EL PASO COUNTY STORMWATER MANAGEMENT PLAN CHECKLIST

Revised 5/21/07

GRADING & EROSION CONTROL PLAN  
LOT 3, PADMARK BUSINESS PARK FIL. NO. 1  
JOB NO. 44-031  
DATE PREPARED: JUNE 29, 2018  
DATE REVISED:

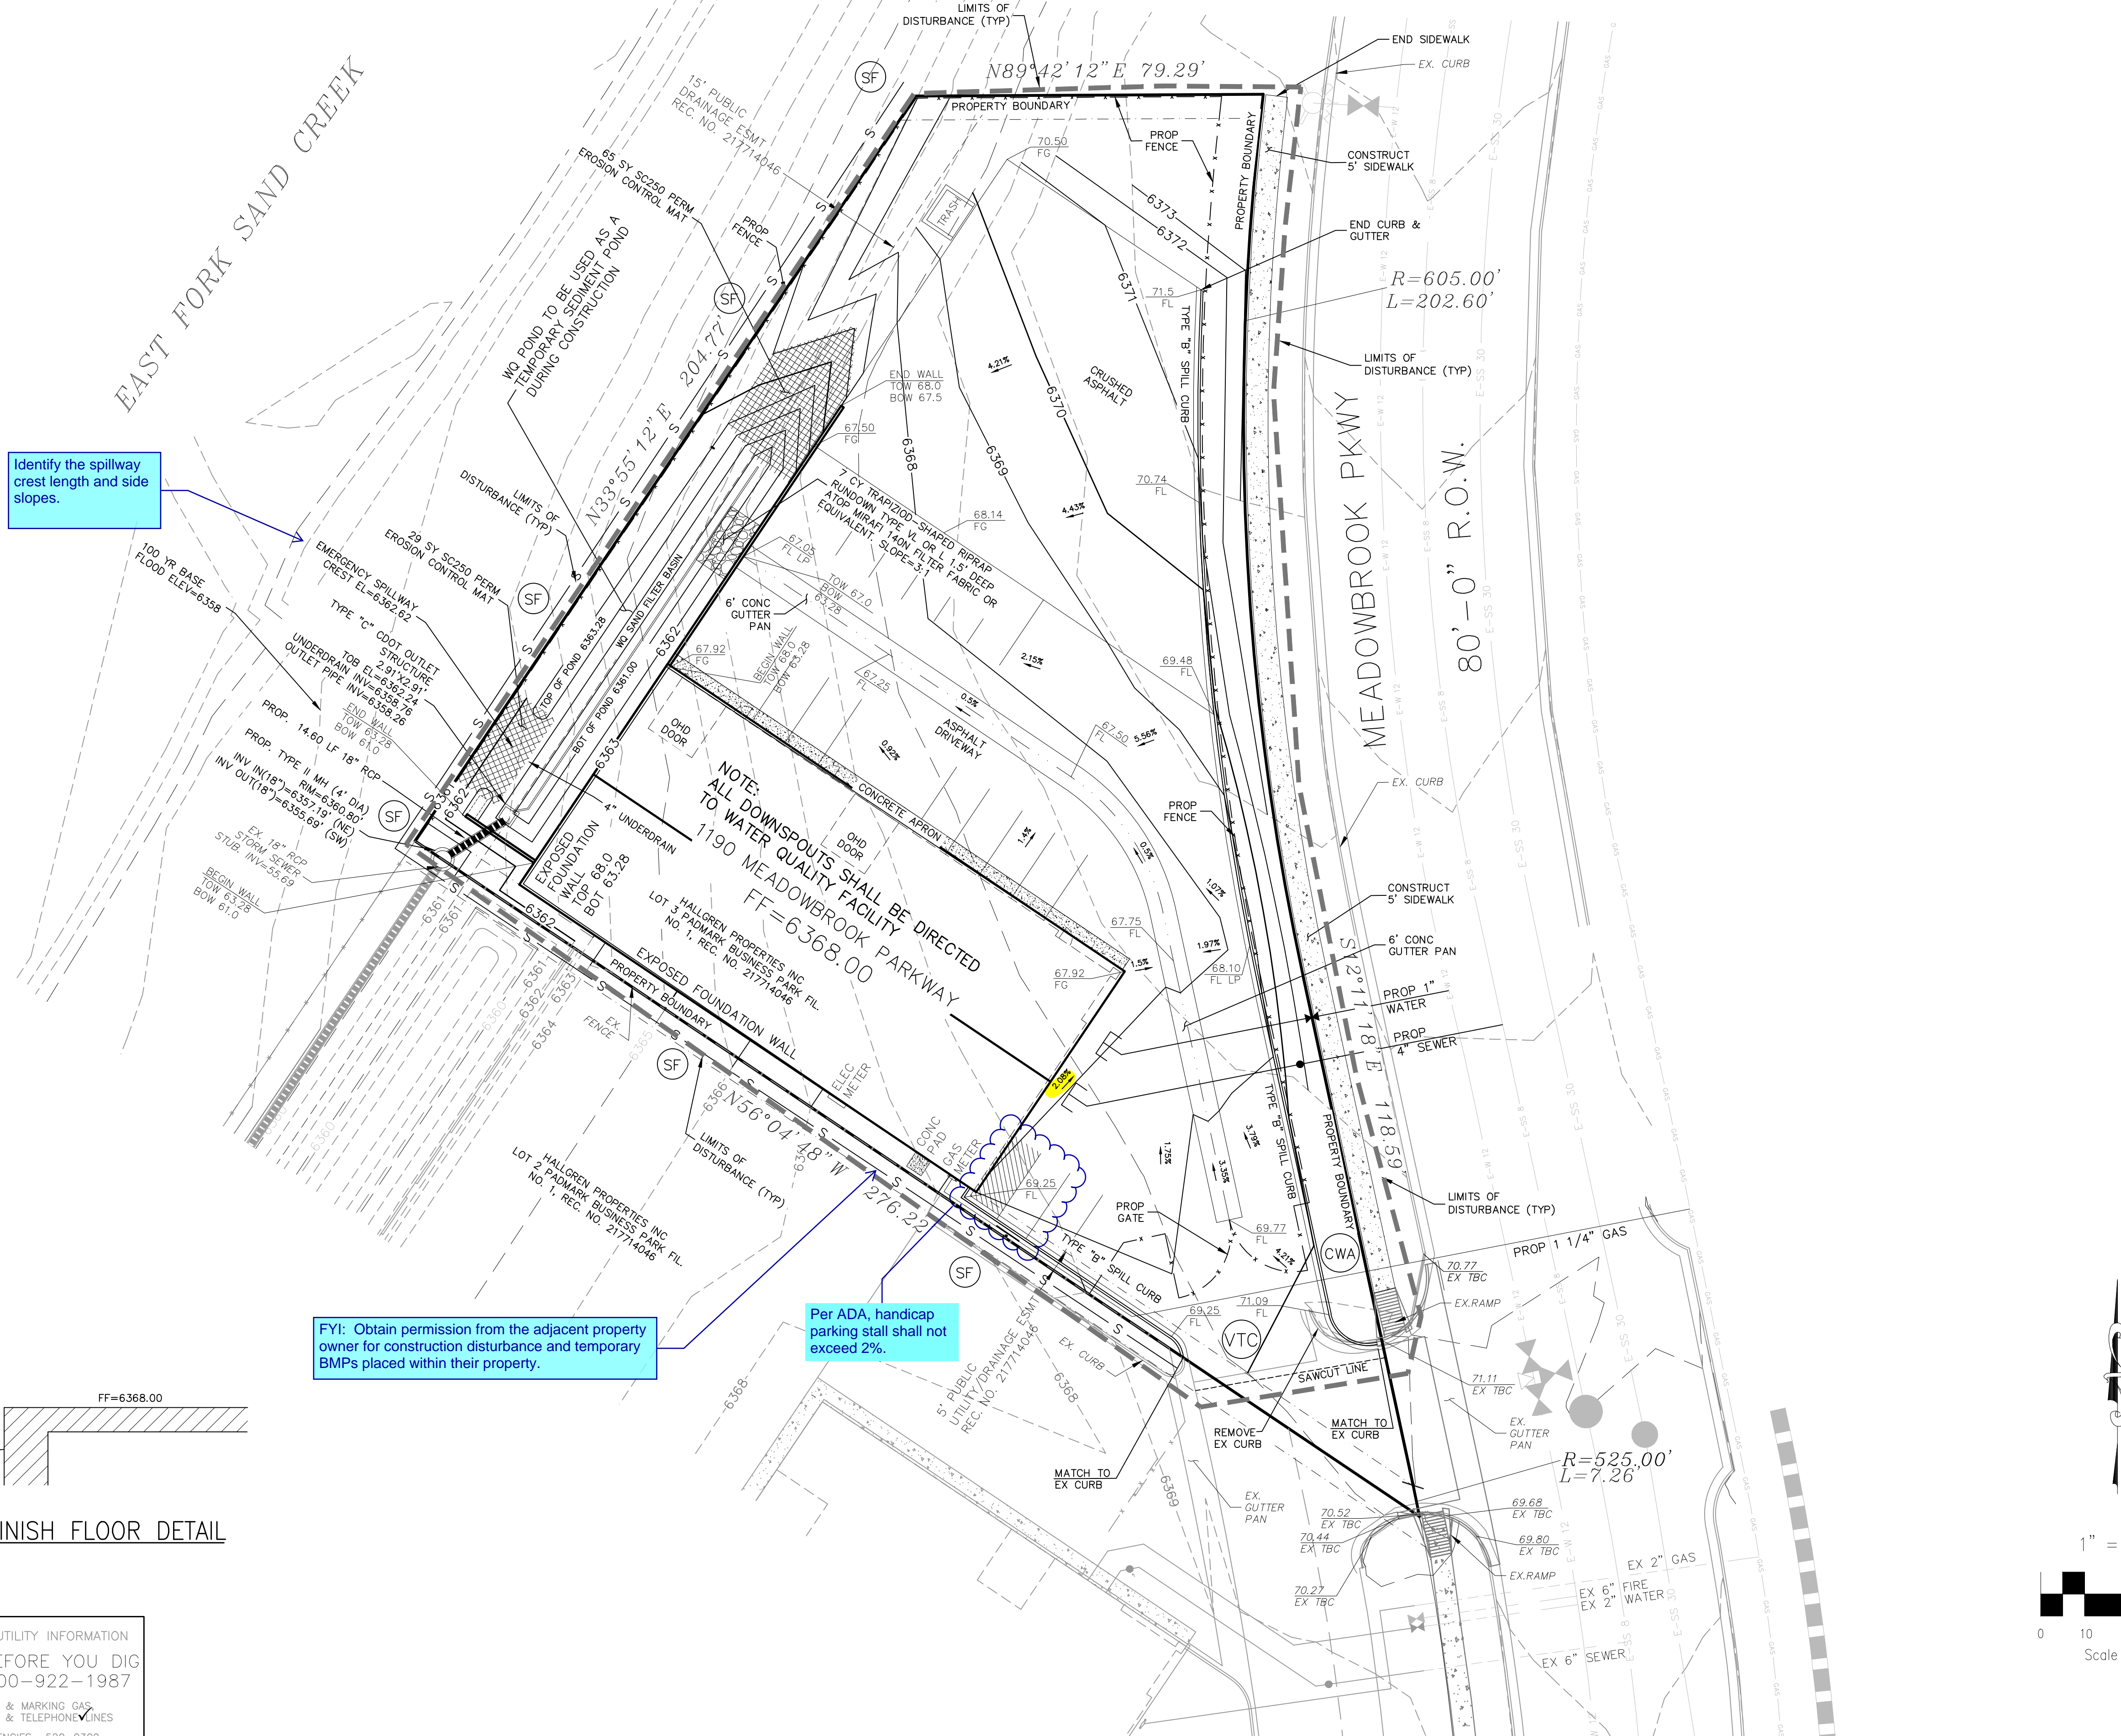
Per the note at the end of the checklist, provide a statement indicating no dedicated batch plant on-site if item 13 and 17e are not applicable..
